From: Contact Centre (CRM) <contact@ribblevalley.gov.uk>
Sent: 06 October 2025 23:18
To: Planning
Subject: Planning Application Comments - 3/2025/0712 FS-Case-755023302

Planning Application Reference No.: 3/2025/0712

Address of Development: Skipton Building Society, Market Place, Clitheroe

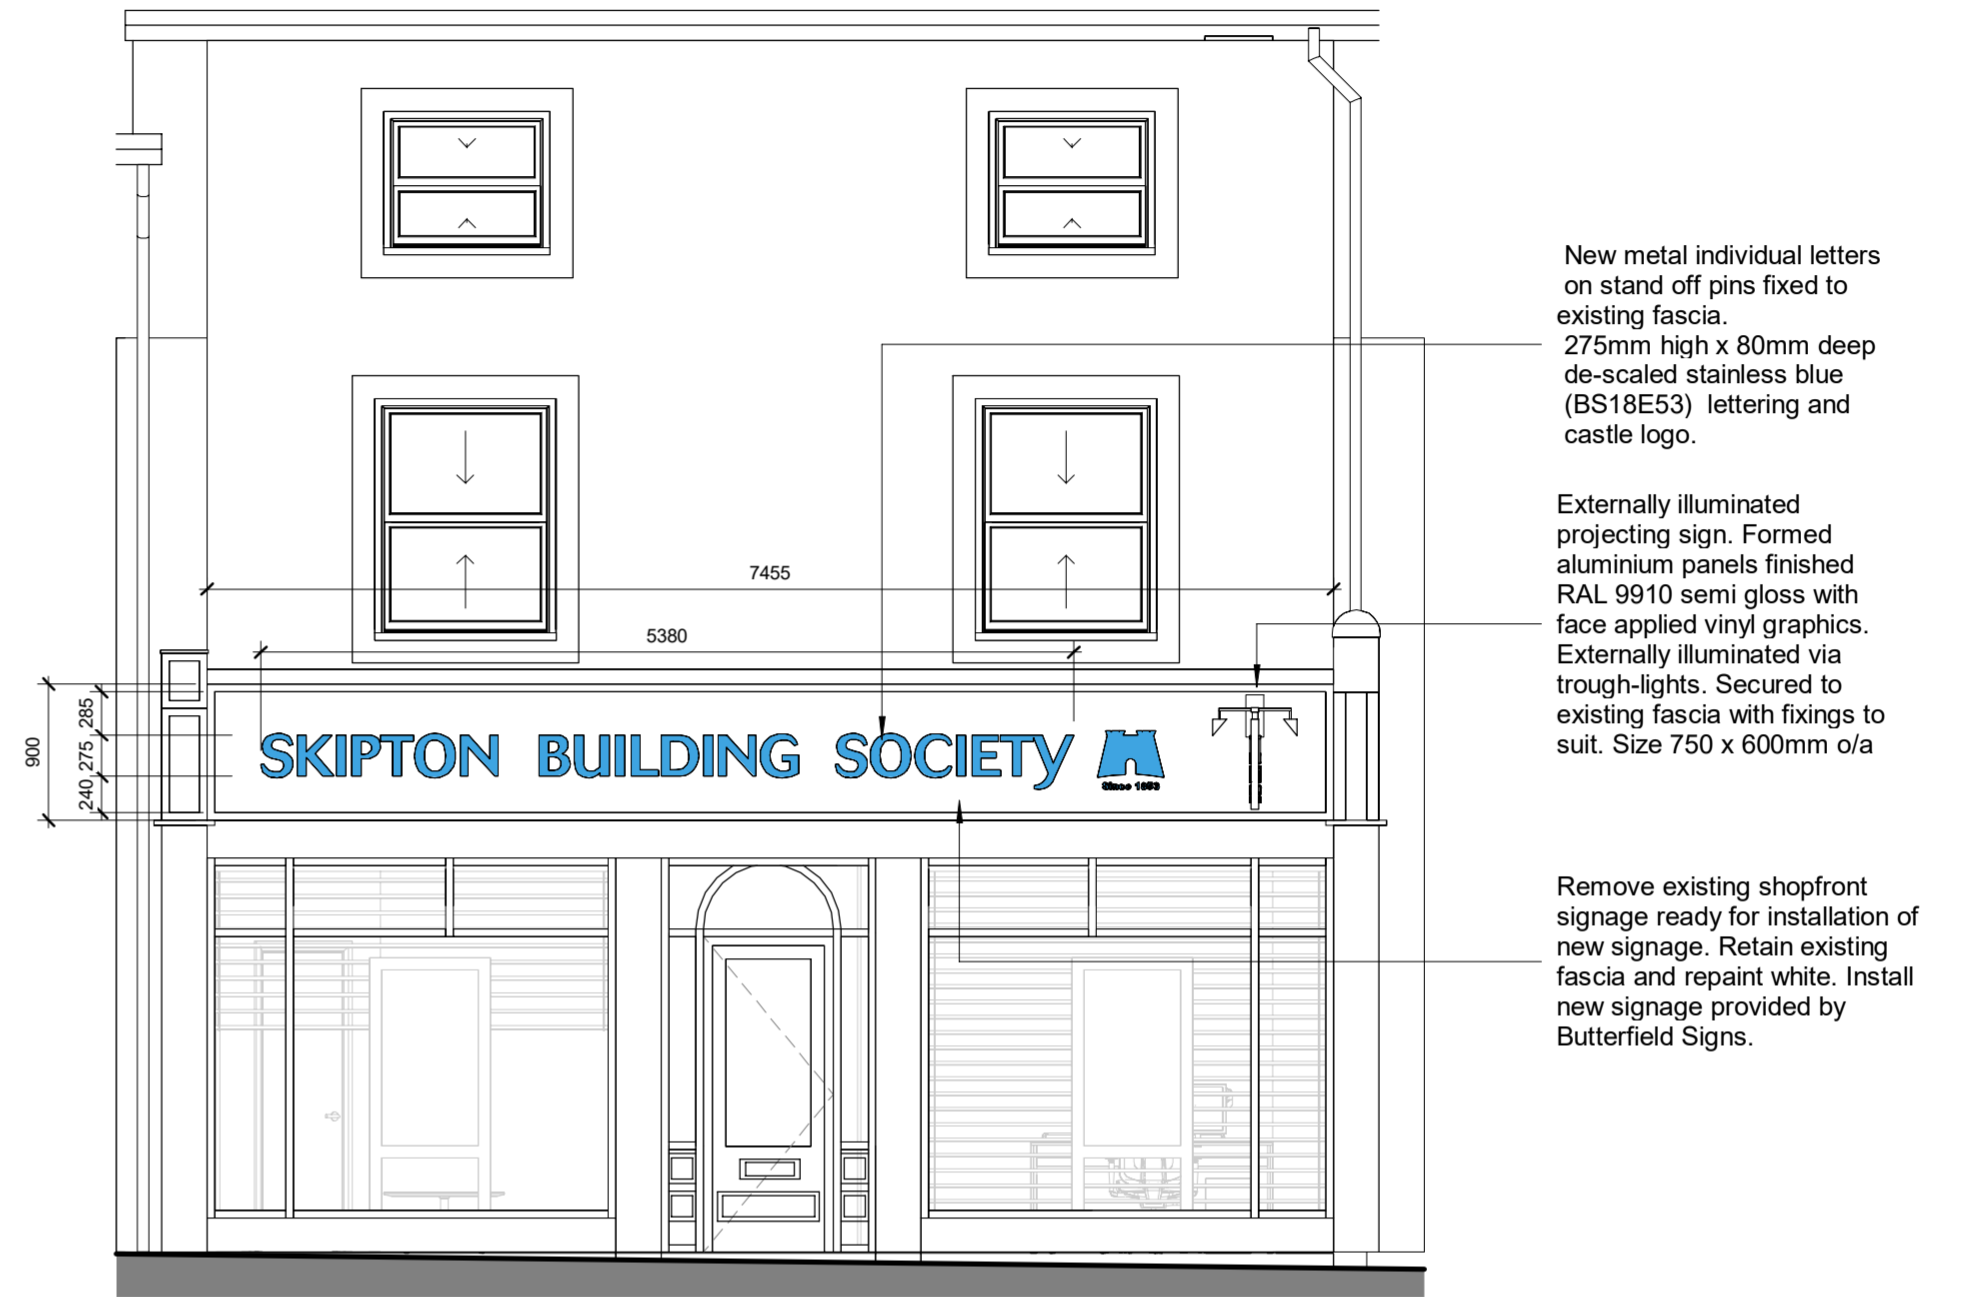
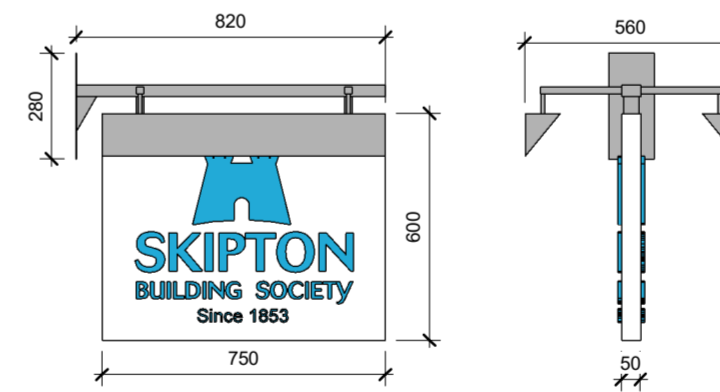
Comments: I submit comments on behalf of [REDACTED] re Skipton Building Society (3/2025/0712) where we do not think the application suitable for a conservation area. The application makes no reference whatsoever to the CA status or acknowledgement of the building's history. This particular building isn't listed, although the majority of the others on the street are. The building is clearly the same building as that in old photos when it was the Boar's Head and it hasn't been rebuilt. There is absolutely no justification for illuminated lighting as part of the shopfront at this location. It's use at this site is excessive, incongruous and is harmful to the CA, and also contrary to the CA management guidance. It looks to be part of a company-wide rebranding exercise however they still need to adapt their design for historic town centres. On that basis [REDACTED] does not support this application, we believe it needs alteration and in its current form, needs to be declined.
